REPORT UPDATE

Application No :	AW/50/08
Agenda Page No :	
Reason for the Update/Changes <ul style="list-style-type: none">• Four letters of objection will add to the existing parking problems. Will not compliment the character of the area. The site is too small. The existing house is bedsits. Would overlook neighbours. Views will be obscured.	
Officer Comment : <p>Noted. The alleged change of use will be investigated by the Compliance Team. The site is considered satisfactory. There will be no direct overlooking of neighbours. There is no right to a view.</p>	
Notes: Changes to recommendations, conditions and/or reasons for refusal will always be accompanied by a new replacement recommendation sheet.

PLANNING APPLICATION REPORT**REF NO:** AW/50/08/**LOCATION:** 14 Tangmere Gardens
Aldwick**PROPOSAL:** Outline application for the erection of 1 no attached dwelling.**SITE AND SURROUNDINGS****DESCRIPTION OF APPLICATION**

SITE PLAN - 1/500

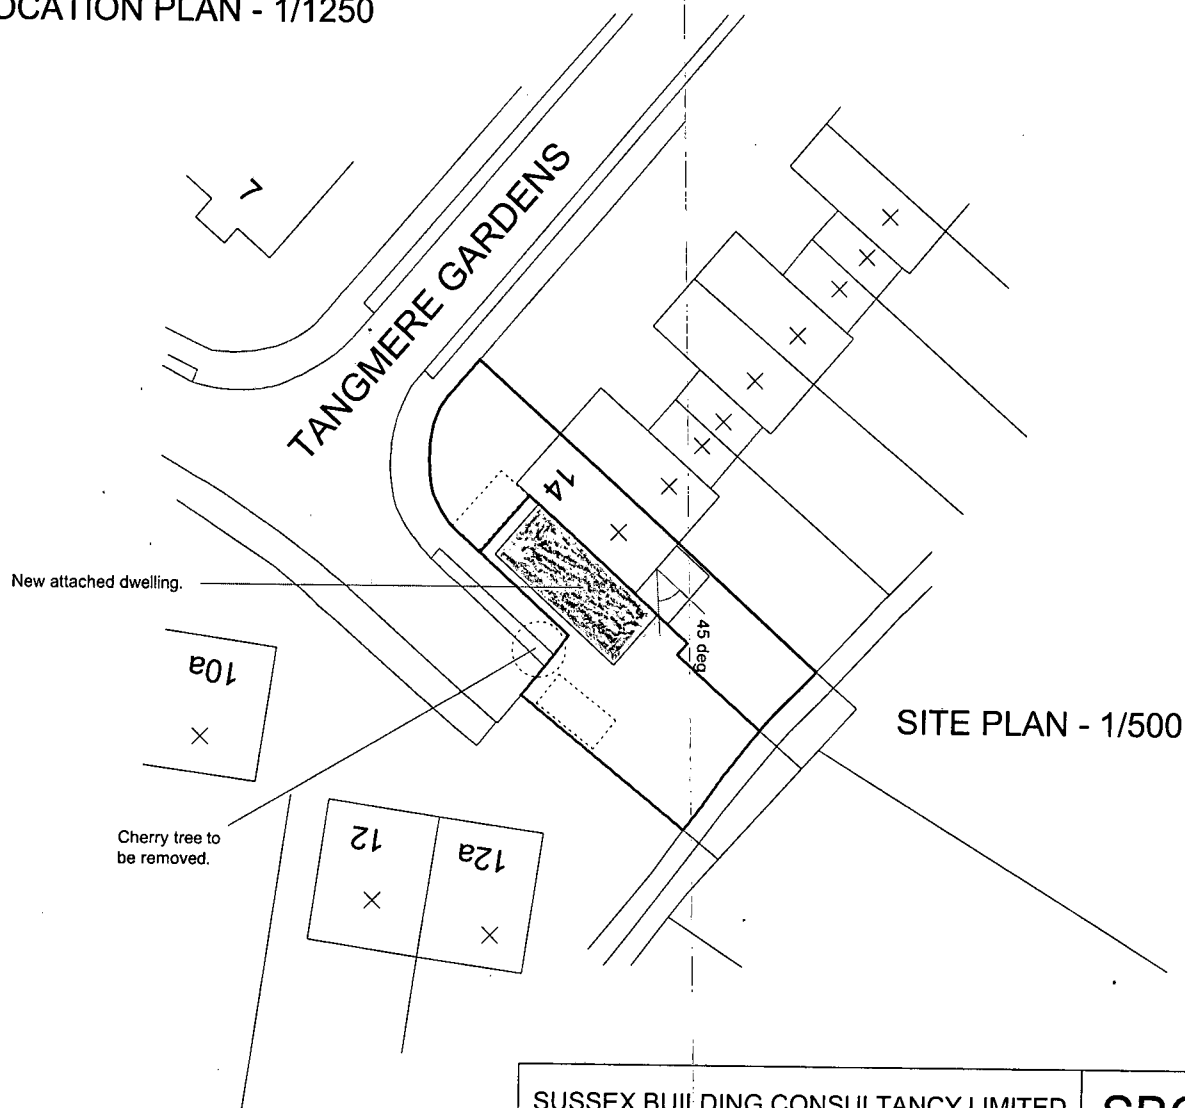
The proposal is considered to comply with relevant Development Plan policies in that the access is as existing and could easily serve both the existing and proposed dwellings. This part of the Gardens is effectively by a cul-de-sac with a mix of dwellings, detached, semi-detached houses and bungalows. The proposed layout would not adversely affect either the street scene or neighbours.

The proposed layout is to set the new house back from the existing frontage by 2m. This would effectively prevent the visual appearance of a terrace.

The scale of the layout of the proposed dwelling matches that of the existing property. Actual design is reserved for a later application. The proposed access and layout are considered satisfactory and therefore it is recommended that the application is approved subject to the conditions set out overleaf.

- 3 The dwelling shall not be occupied until the parking spaces and garages shown on the submitted plans have been provided and constructed. The areas of land so provided shall not thereafter be used for any purpose other than the parking and garaging of vehicles.
